FIRE RISK MANAGEMENT, INC

Memo Report

Subject: Independent Fire Protection Review for Cumberland County Civic Center Renovations

A review has been completed of the updated sets of fire protection construction documents (CD), which have been developed to support renovation efforts at the Cumberland County Civic Center in Portland, ME. The documents reviewed included both the fire protection demolition and design drawings (updated 4/12/13), along with the design specifications (updated 4/2/13) for the various fire protection and life safety related systems and the Building Code Report (dated 4/16/13).

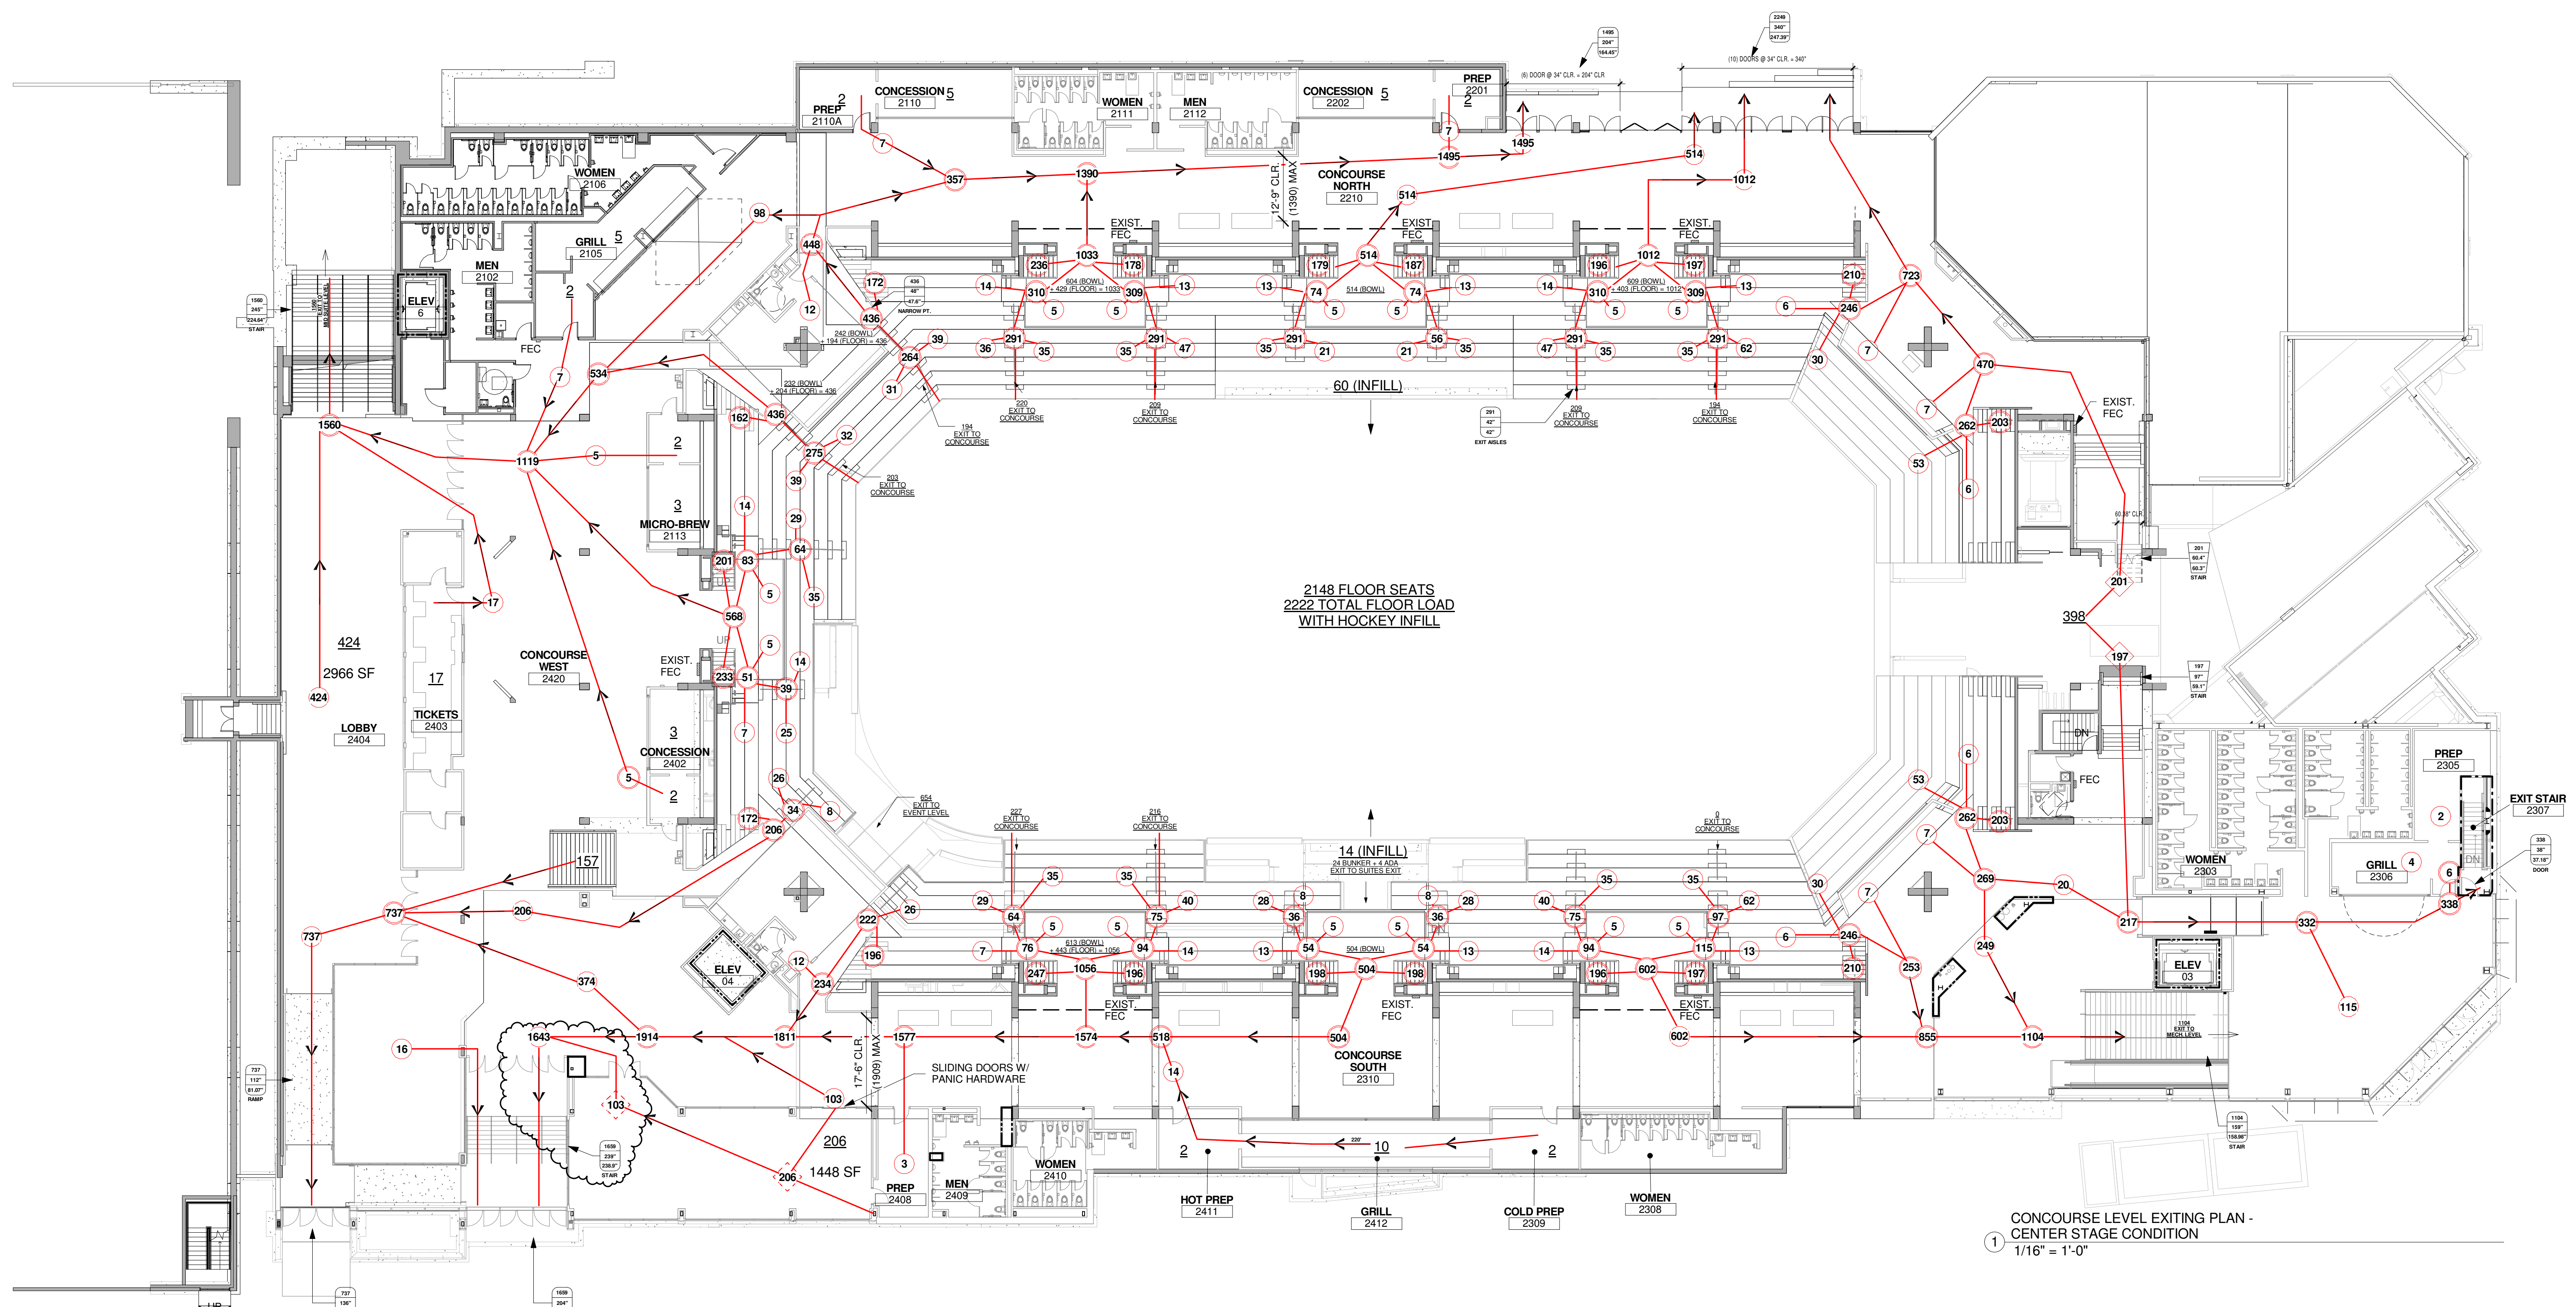
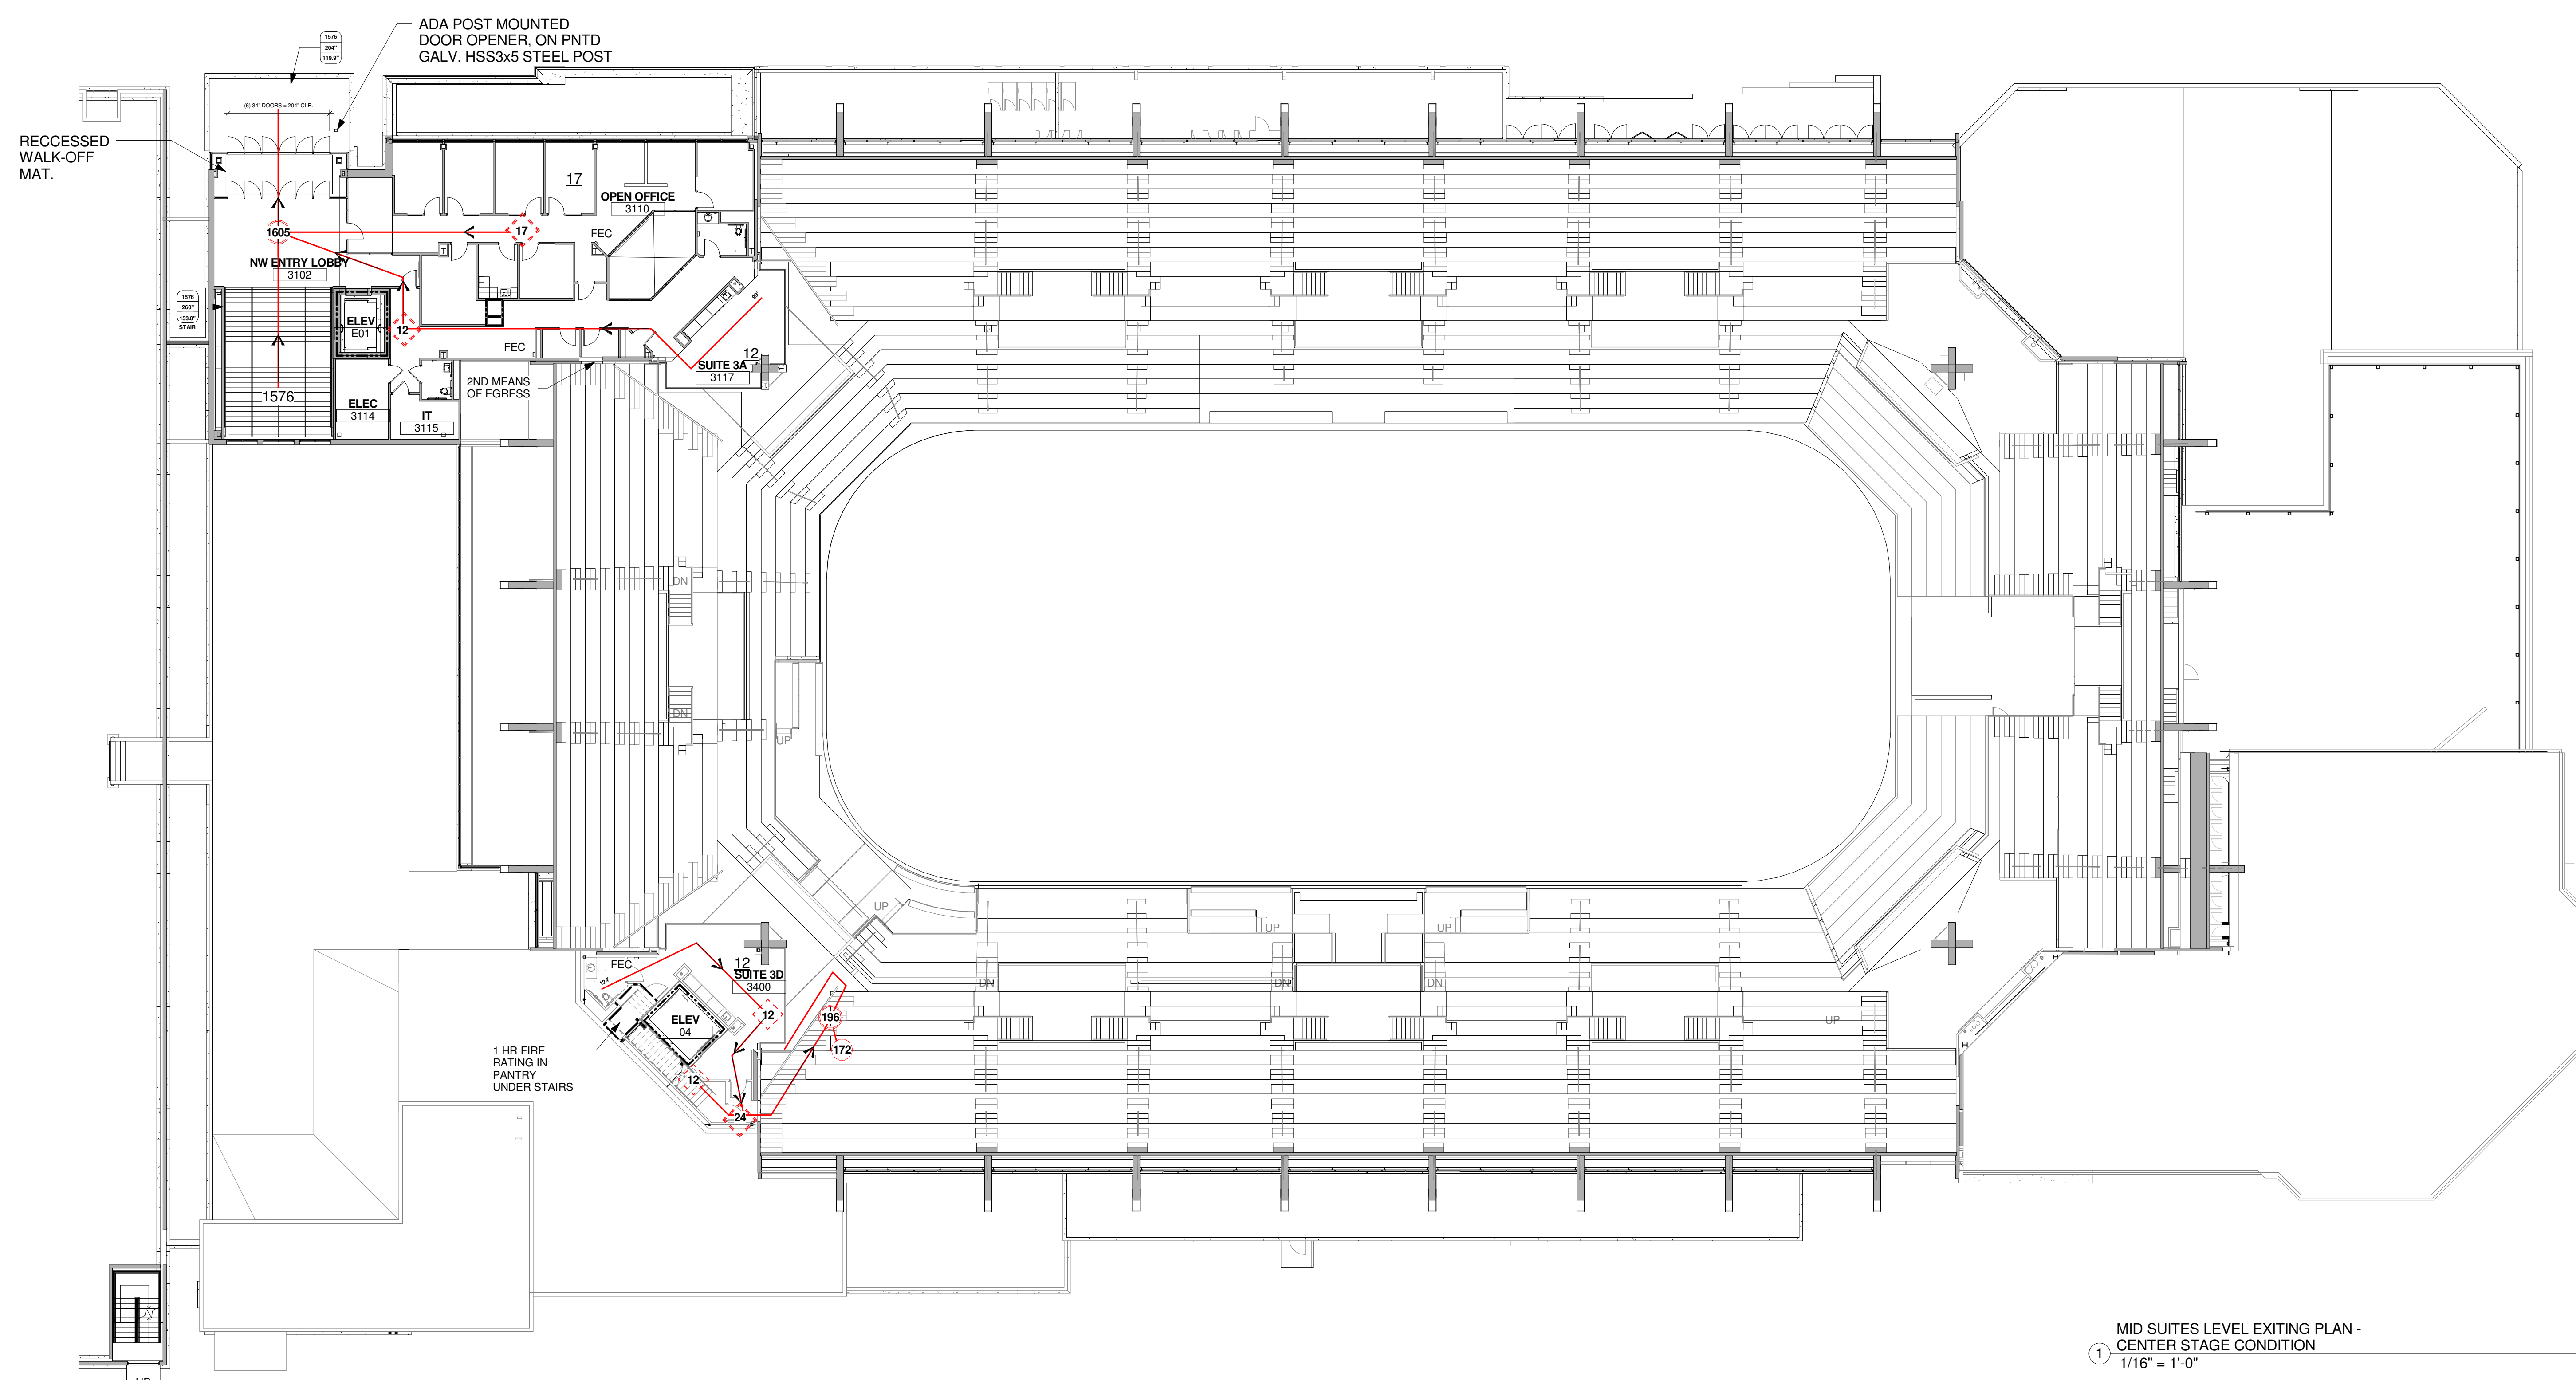
Some of the fire barrier requirements are still not properly depicted on the Life Safety (LS) Plans. For example, no fire rated barrier is shown for the Fire Pump Room; albeit other drawings properly indicate that the pump room will be isolated by walls having a 1-hour fire resistance rating. Is the elevator pit for elevator in the Mechanical Level open to the Elevator Machinery Room? If so, the machinery room needs to be isolated from the rest of the building with barriers having the same fire resistance rating as the elevator shaft (at least 1-hour, since this connects only three floors); otherwise, will simply need to ensure that any penetrations between these two areas are provided with proper penetration seal materials. Also, the store room adjacent to the elevator machinery room indicates the need for a 1-hour fire barrier. Is this meant to include the bounding walls of the store room or simply for the ceiling above? This should be better clarified, since the room itself would not require such a fire rating.

The occupant load calculations for the home team locker room and its associated spaces/areas, including office areas, do not appear to accurately reflect the load factors that should be applied within all the various spaces. Also, the stair located on the west end of the Event Level that leads up to the Concourse Level, does not appear to be provided with intermediate railings. These stairs appear to be much wider than the 5-foot (60 inch) maximum that would be allowed without the need to install additional handrails. [Note: An 88 inch maximum distance between handrails is allowed for "existing" buildings.] The current plan for the design of these stairs should be reviewed to determine if an additional handrail(s) is needed.

The path of egress from the Commissary area should be revised to properly reflect the actual path of travel to be used. Currently the path indicated depicts travel "through" a wall(s). Although the maximum travel distance will not be problematic, the path shown on the LS Plans should still reflect the code-required path of travel.

The location of the Fire Command Center should be identified on the LS Plans.
